**Planning Application No: 3/2025/0986**

**Proposal: Partial demolition of existing garage workshop and new build works to form 2 bed holiday accommodation and mezzanine floor.**

**Location: Land opposite Turner Fold Read BB12 7QZ**

**App no: 24.0612**

PROPOSED BLOCK PLAN 1:200

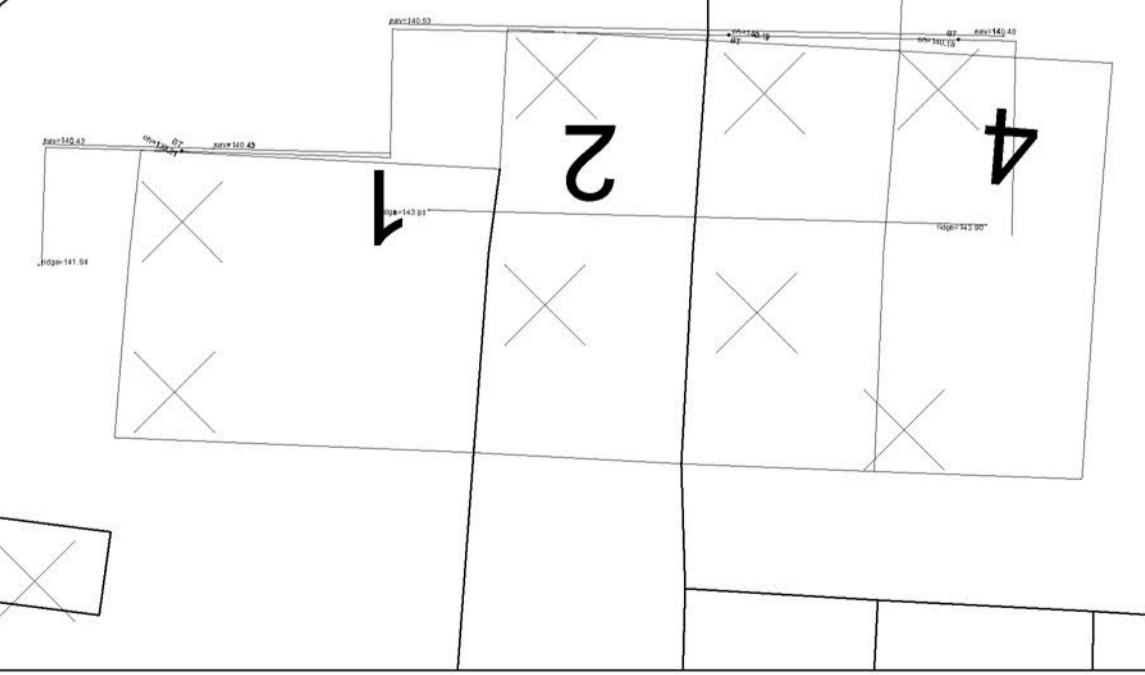
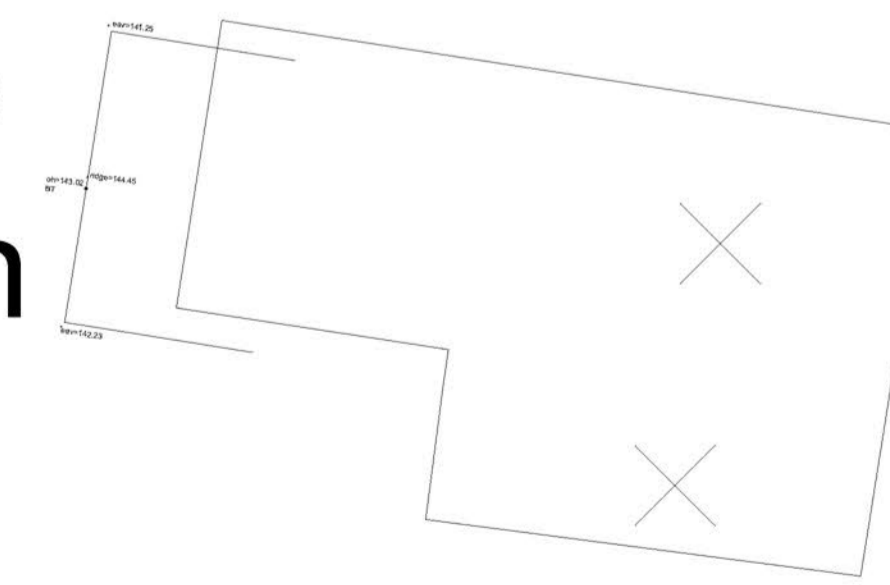
*There are no changes proposed to the access itself however the internal area will be increased in size to accommodate 4 car parking spaces.*

*The applicant confirms that the off-street parking shown at no.3 Turner Fold was an error. Upon visiting the site, it is evident due to the geometry of Turner Fold and the on-street car parking which occurs that vehicle speeds will be below 30mph. A visibility splay drawing is provided, as requested which shows splays of 2m by 17m to the east side and 2m by 43m. This is considered acceptable.*

*The surface materials of the additional area of hardstanding for parking must to be paved in a bound and porous material and surface water drainage needs collecting before it enters Turner Fold.*

1. Prior to first use of the development hereby permitted, the car parking shown on the approved plans shall be provided and paved in a bound and porous material. Surface water shall be collected prior to being deposited onto the adjoining highway Turner Fold. Reason: For highway safety.
2. Prior to first use of the development hereby permitted a secure cycle store for 2 bicycles shall be provided and maintained thereafter for that purpose. Reason: To support sustainable travel.
3. The visibility splays shown on the submitted drawing shall be maintained with all vegetation, walls, fences, etc shall be kept below 1m high in perpetuity. Reason: For highway safety.
